Re: Objection to MP08-0244 MOD 1 Modification Request for Mixed Used Development at 23-37 Lindfield Avenue and 11 Havilah Lane, Lindfield.

ELEVATIONS

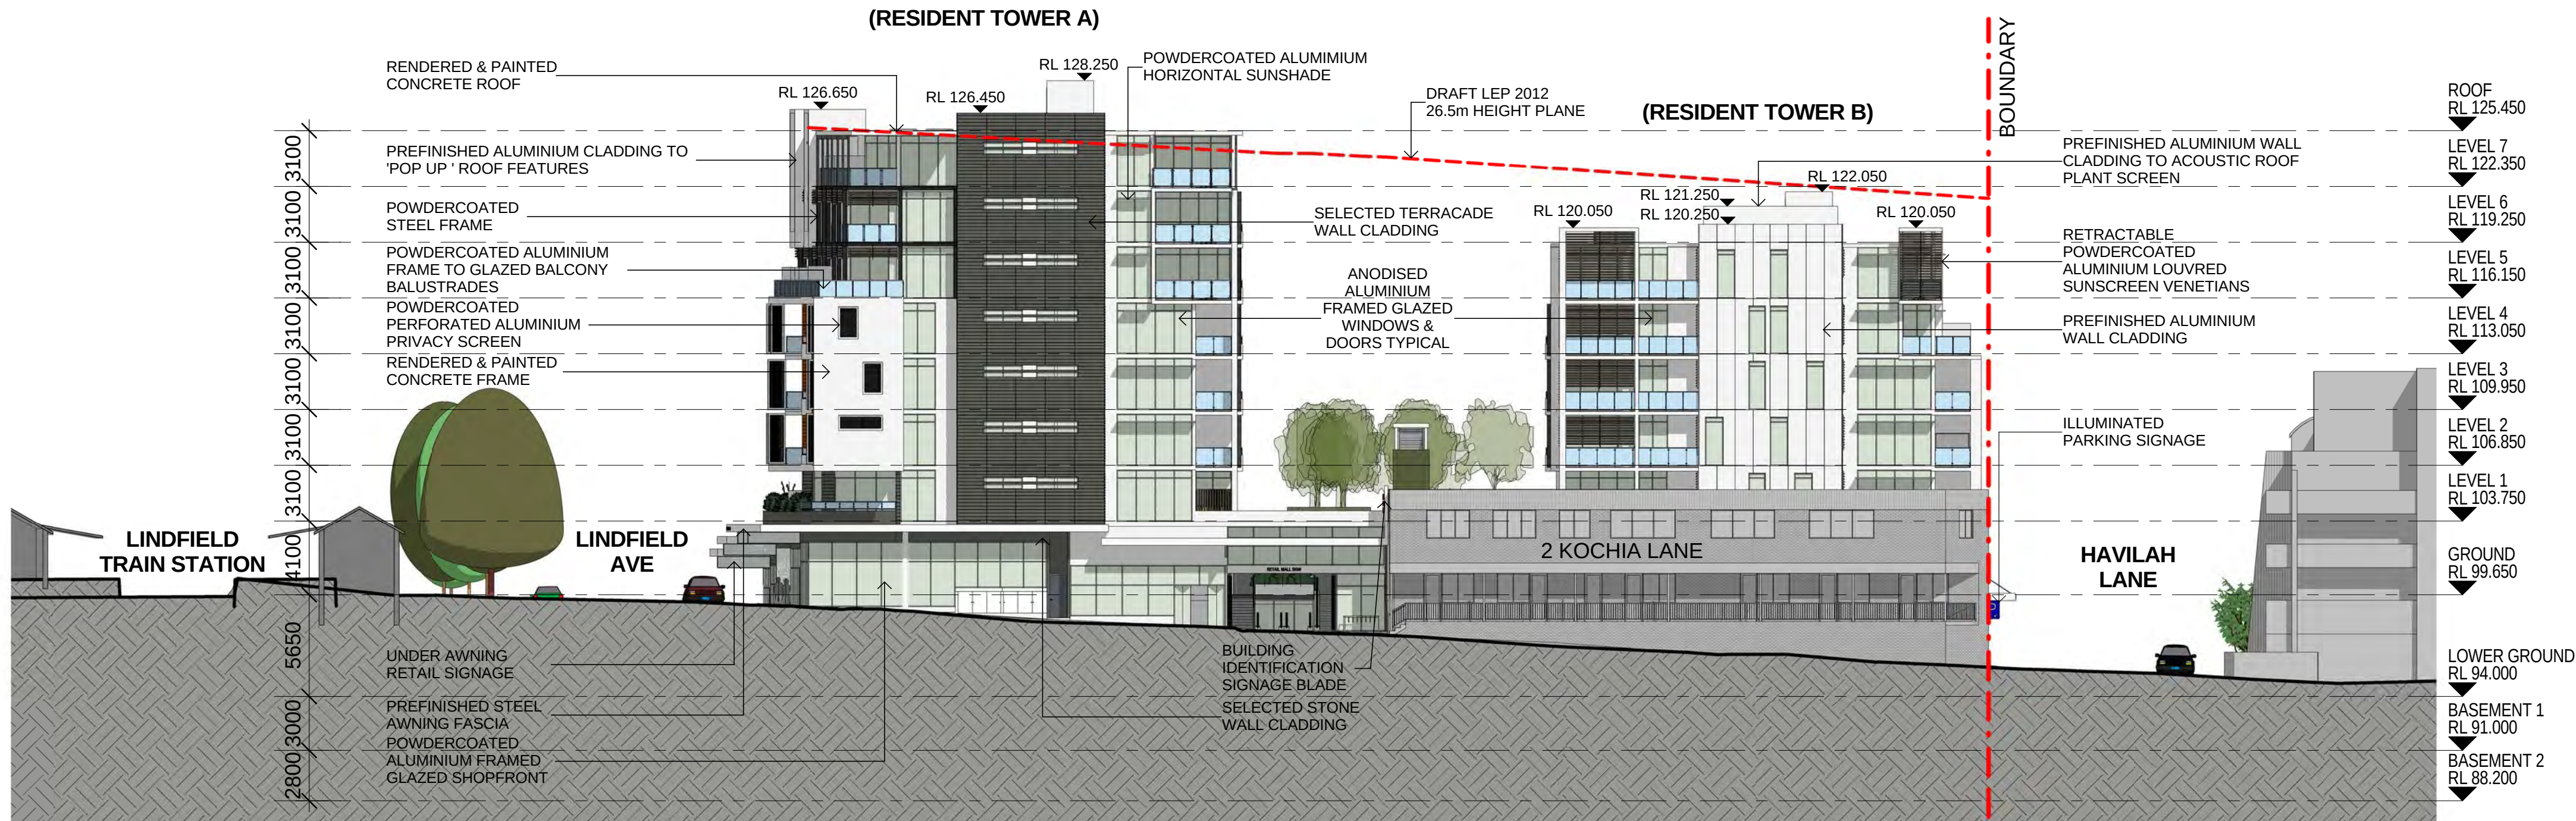
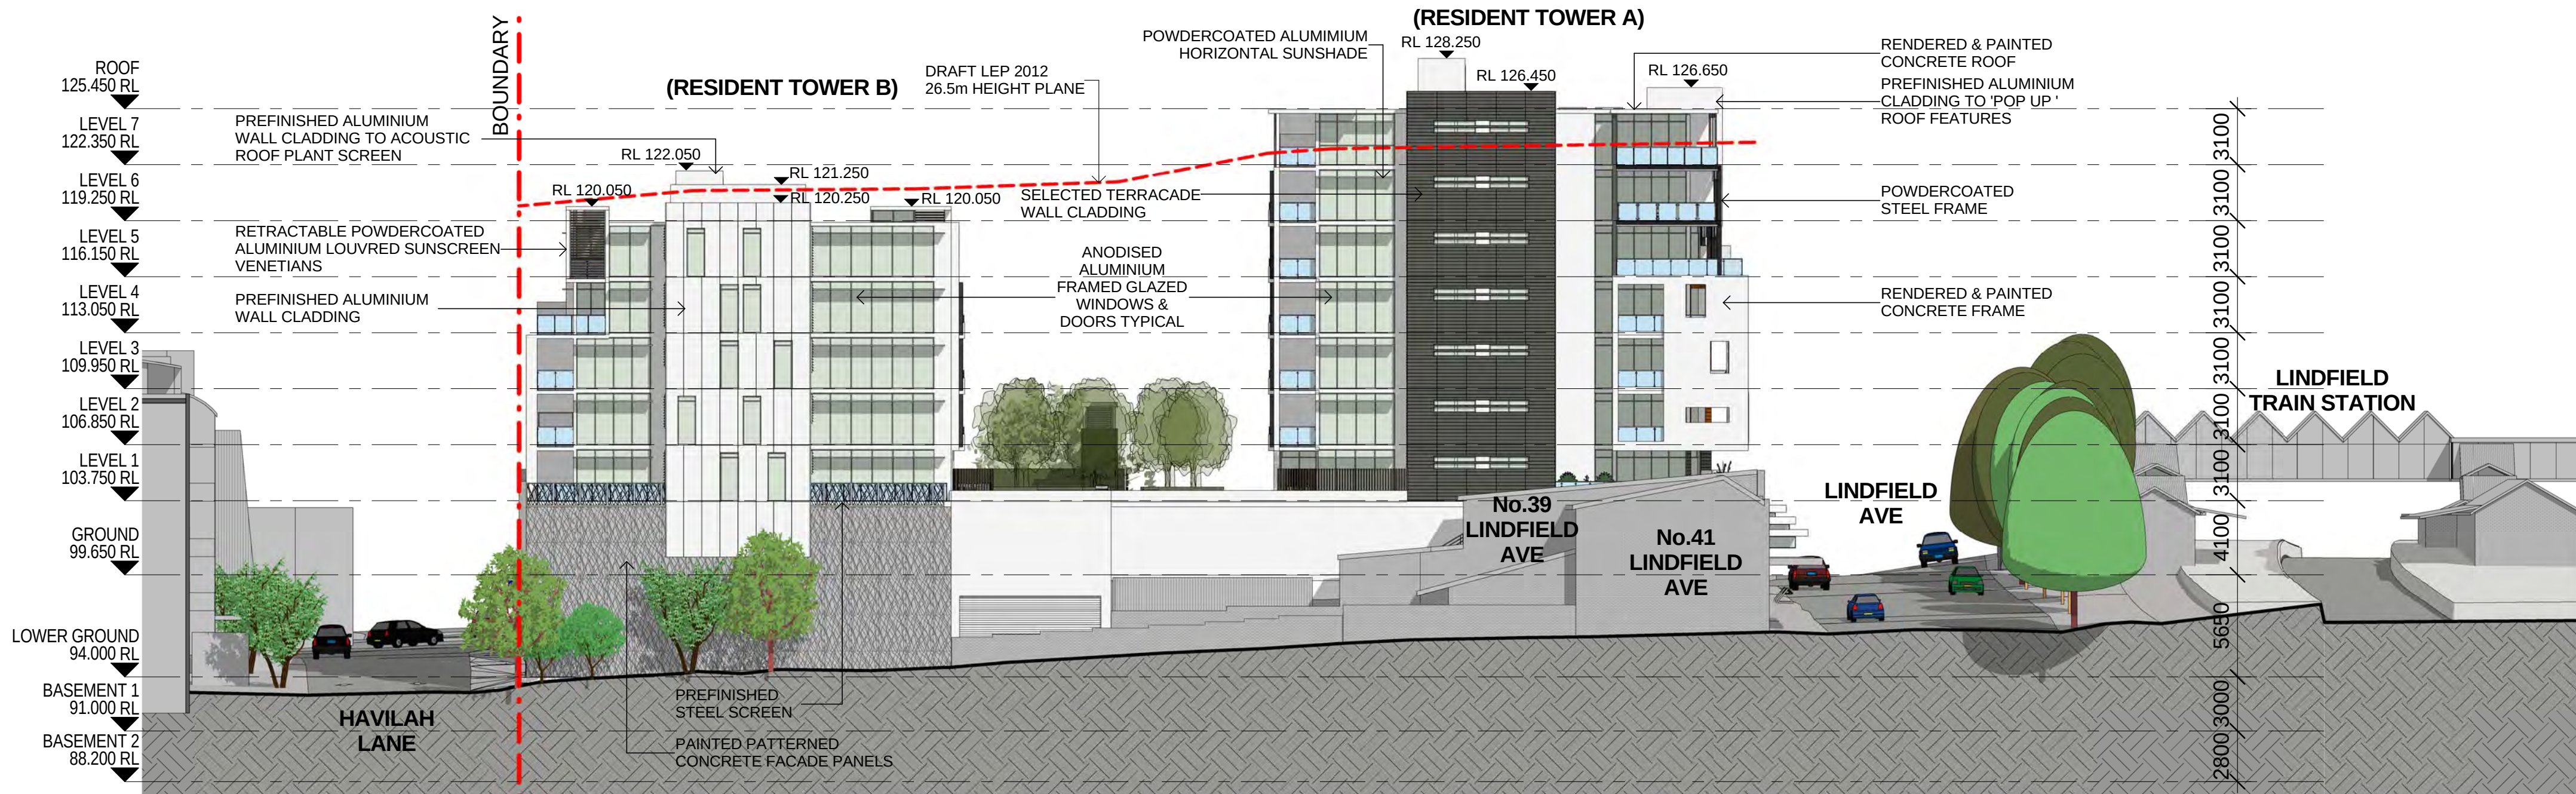
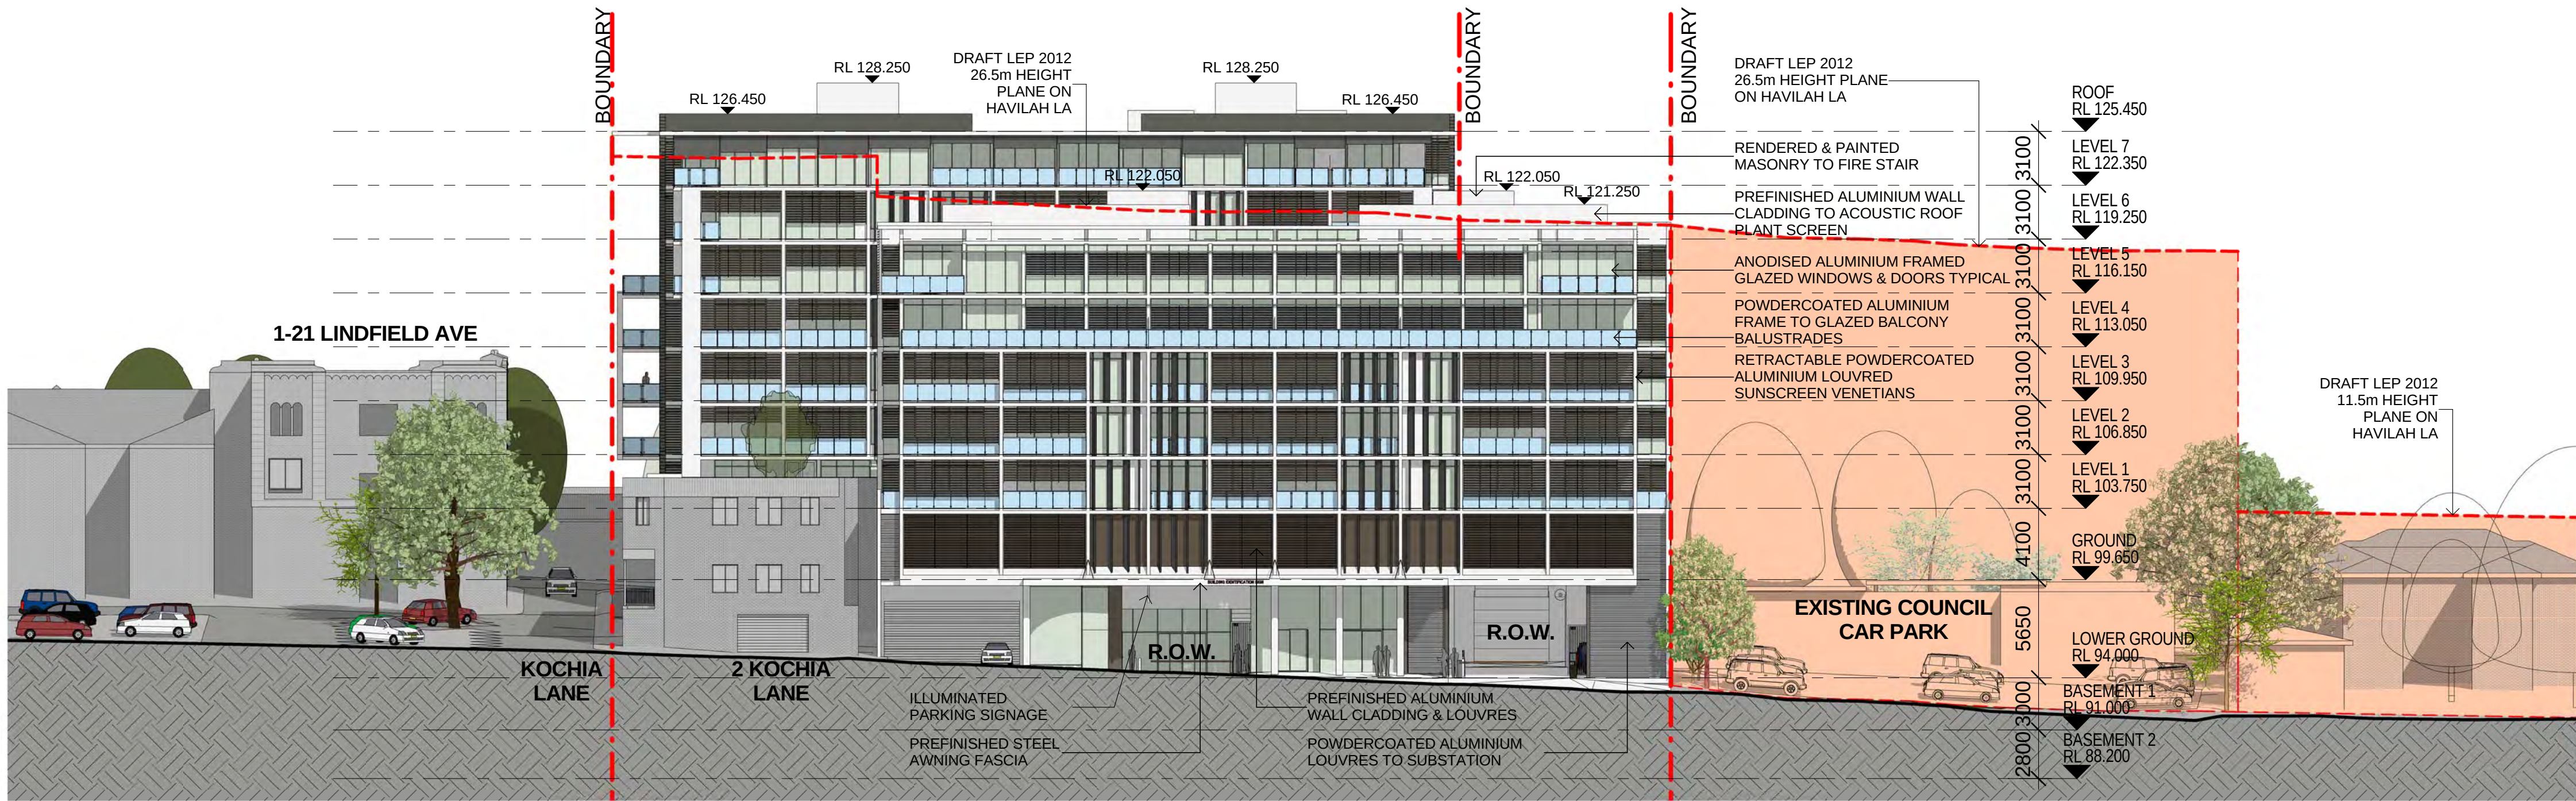
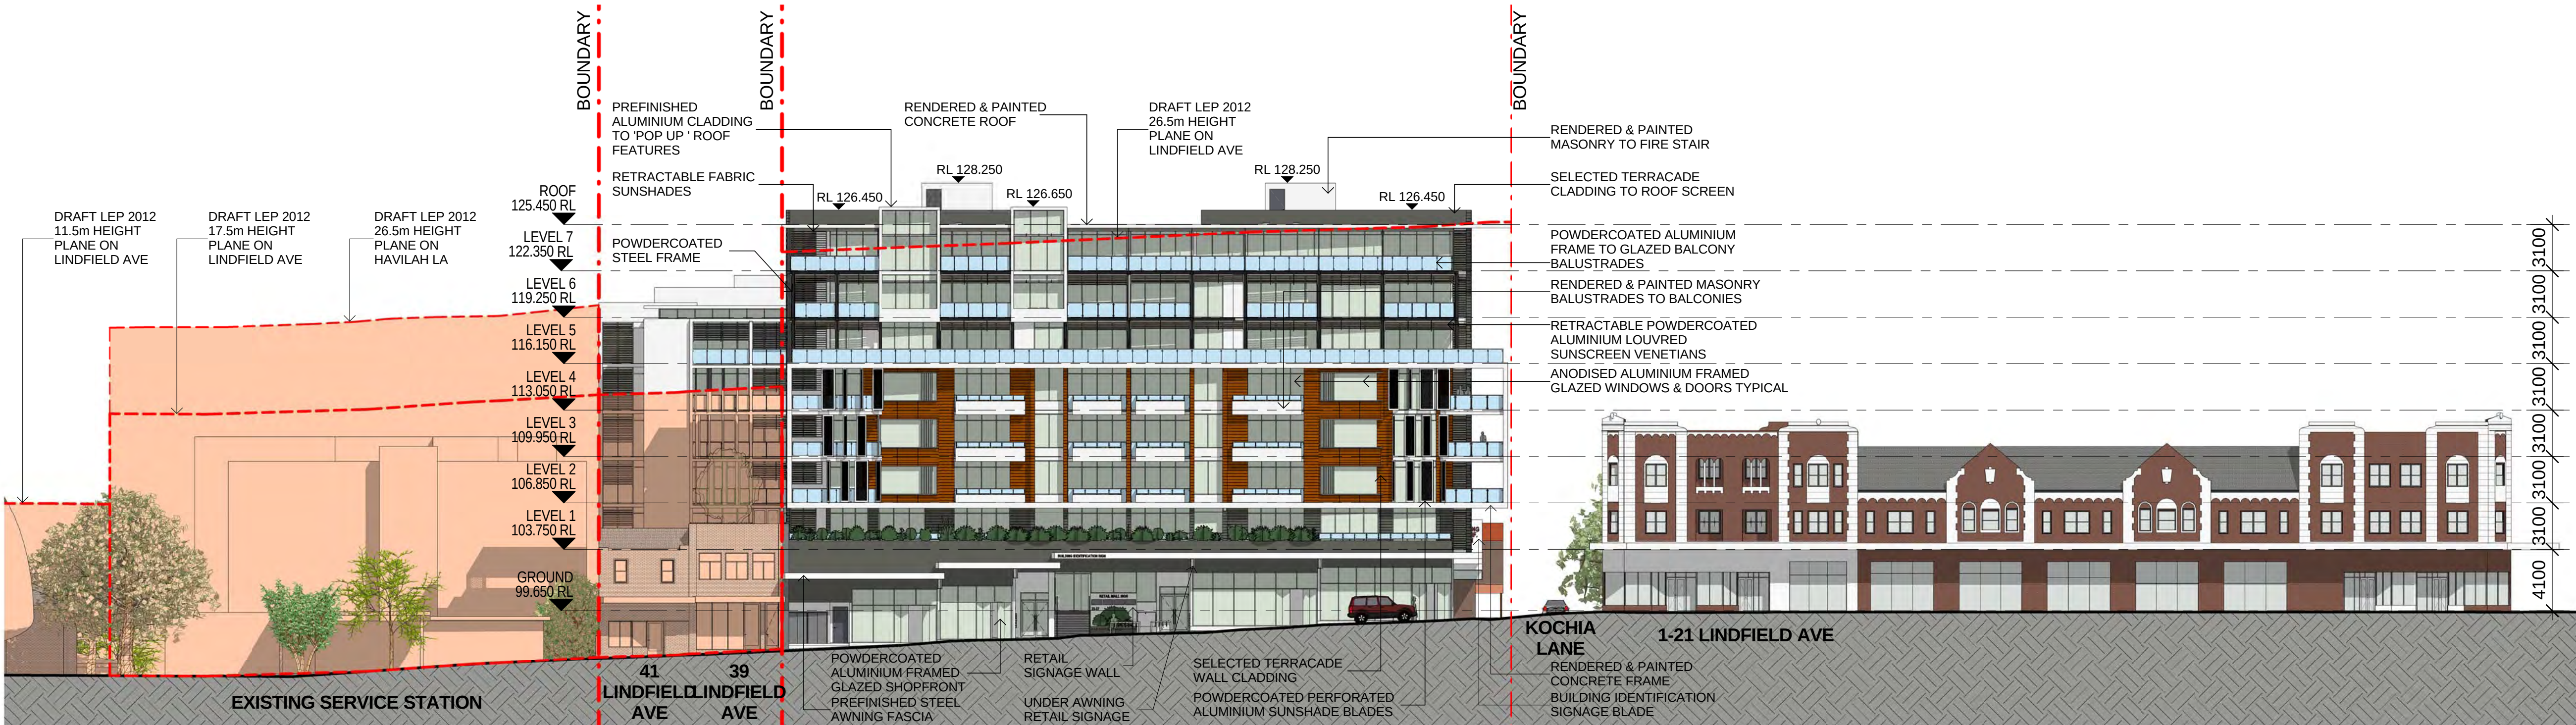
The increase of an additional storeys to both buildings: 8 storeys on Lindfield Avenue and 7 storeys on Havilah Lane. I believe this creates excessive height and bulk and is out of character with the surrounding buildings, including the heritage listed adjacent building on Lindfield Avenue.
